From: Maria Tomalova
Sent: 15 February 2023 12:46
To: Planning.Responses
Subject: Y/52/22/DOC, Stakers Farm
Attachments: 1020-06G Stakers Farm Yapton Proposed Elevations A1.pdf

From: Zac Denton [REDACTED]
Sent: 25 July 2022 16:38
To: Daniel Vick <Daniel.Vick@arun.gov.uk>; Maria Tomalova <Maria.Tomalova@arun.gov.uk>
[REDACTED]
Subject: RE: Stakers Farm

We also discussed the DOC for the site Y/5/22/DOC. We would like further details regarding proposed material types e.g. manufacture and specific product with state allowance (or matching alternative if product no available). Martyn did point out that the plans submitted with this DOC were from the current architect rather than the previous who gained approval.

C	VARIOUS AMENDMENTS	03.03.21
B	MINOR AMENDMENTS	25.02.21
A	PROPOSALS AMENDED	05.02.21
REV	DESCRIPTION	DATE

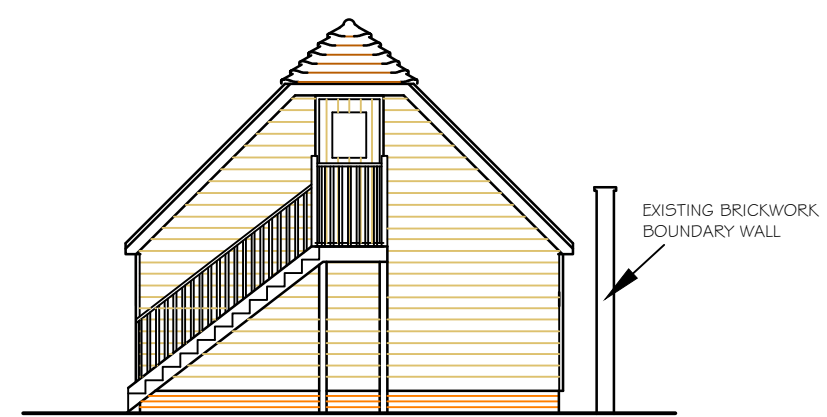
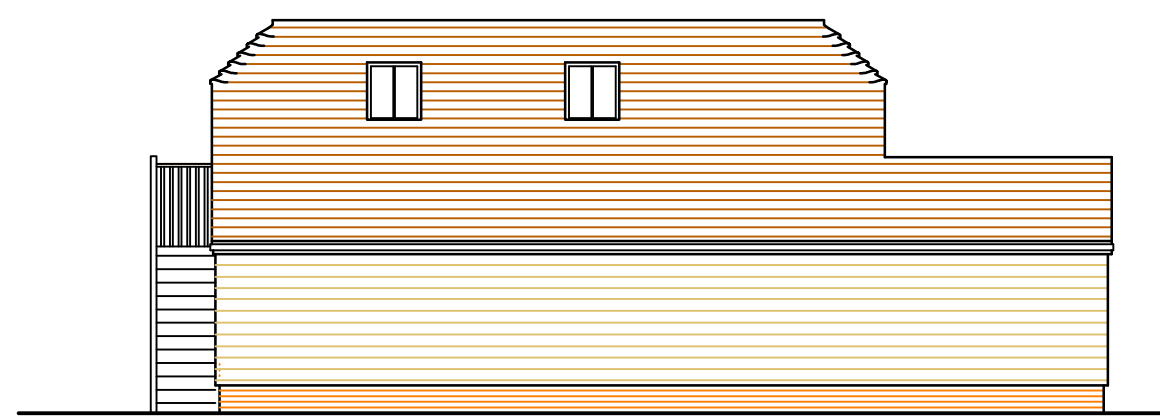
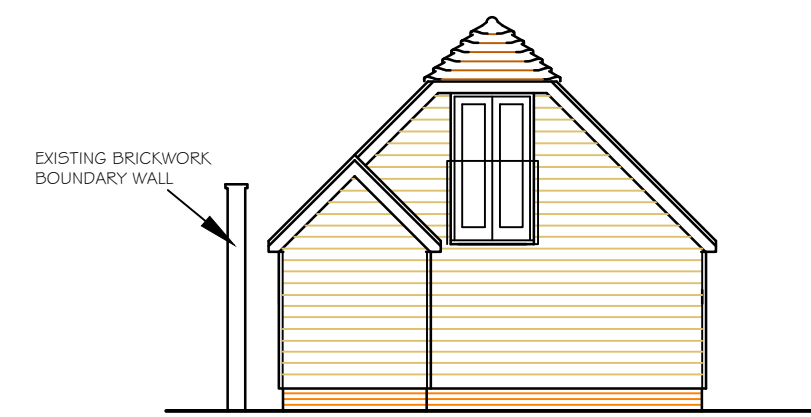
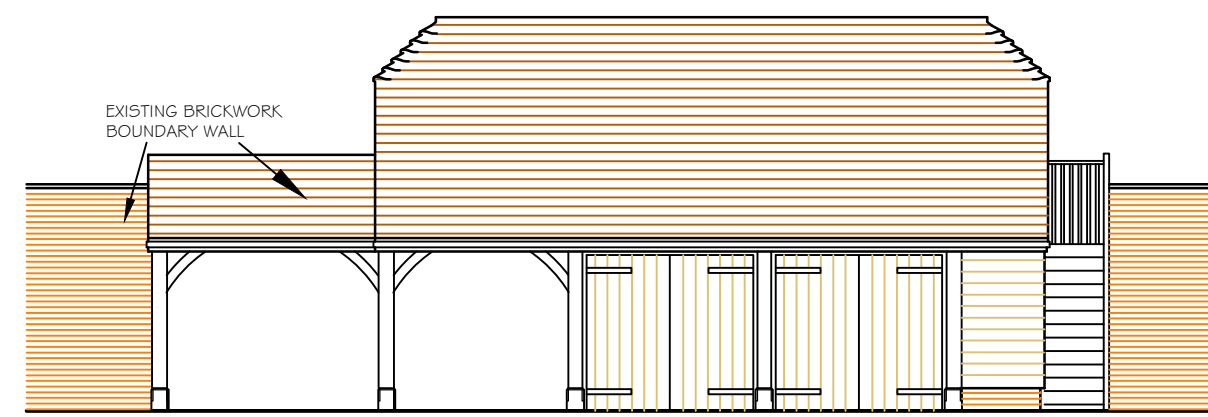
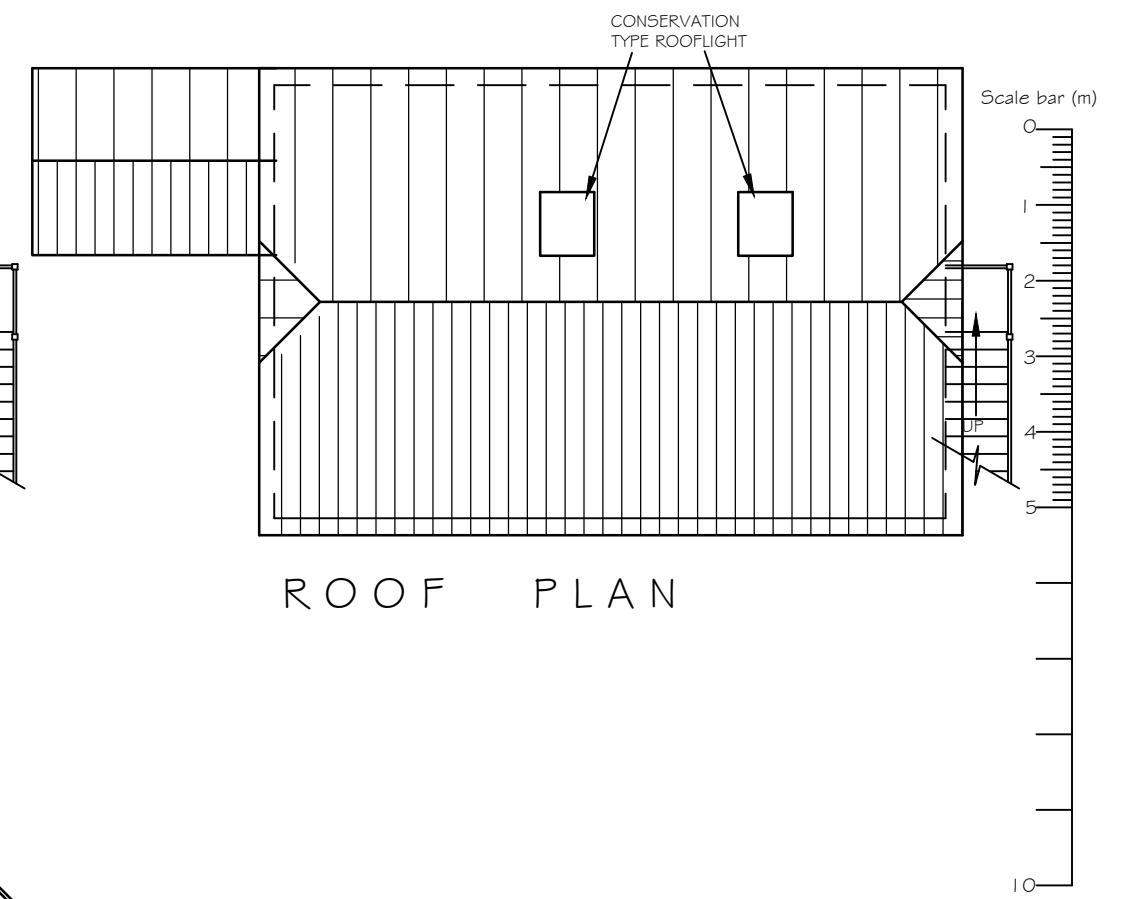
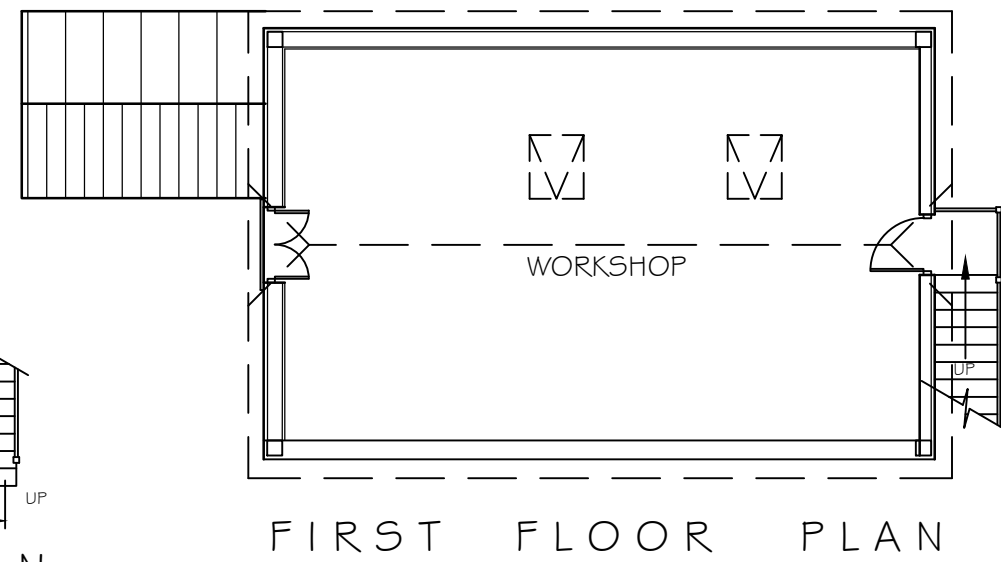
The element above the door is acceptable as you have described below – our concerns came from the way it had been presented on the plan. Brick surrounding the windows in that element is our preference. They should be good quality and match the existing.

In particular the concern related to the materials around the opening in the gap – (apparently wood whereas brick is the preference) and some understanding of what the strip is above the window and below the existing flint area with small window above.

- Barn 2 potential for window to dominate the elevation - As shown on the attached photo, this is an original cart shed opening which has previously been crudely infilled with brickwork and a door. The original timber beam above the opening is still in position, and this will be retained and used as the top of the reinstated opening. The removal of the door and infilled brickwork will reinstate the original opening, and this will be clearly expressed with a simple, full height glazed screen.

- Barn 1 south east elevation - The proposed windows to the south east elevation of Barn One are all within existing openings and would all serve bedrooms. We have now omitted the horizontal boarding to the window serving bedroom 3 and shown this as full height glazing to match the other proposed windows. Can window details be dealt with via condition if needed?

Further to our call last week and the email below, please find attached the amended drawing which addresses the request for brickwork in the cart store opening. I hope this now addresses the comments from Martin.

We have looked closely at this element and the approach is described in the attached. This is an original opening which had been bricked up. We are looking to create openings where these were historically and the lighter weight material is considered to be an appropriate response to that to ensure that the original opening can be appreciated. Use of brick as suggested wouldn't achieve that in our view. However, if amending to brick will allow approval, our client will accept this and we will amend the drawing.

In terms of the strip referenced. This is the existing lintel which will be retained as is. Please see photograph attached.

1. Altered proportions of window on the south-east elevation with the proportional split of openings to be circa 2/3 for the opening and 1/3 for the low level fixed frame
2. Width of fenestration on outshot to the side of the main barn reduced to 2 pane widths.

Re point 2, we are agreeable to amending this, but we do feel that the glazed screen to the outshot roof of the main barn is shown to the correct width. The attached photo clearly shows that this is an area of modern brickwork infill below an historic timber beam. This would originally have been constructed as a cart shed opening, and we would simply be reinstating this opening and expressing it with full height glazing. In our view it would be wrong to reduce the width of this with masonry infill but as we are responding to your comments, we think the design response is more appropriate with timber boarding to both sides and glazing in the middle in order that the original opening size can still be clearly understood. The attached drawing reflects this.
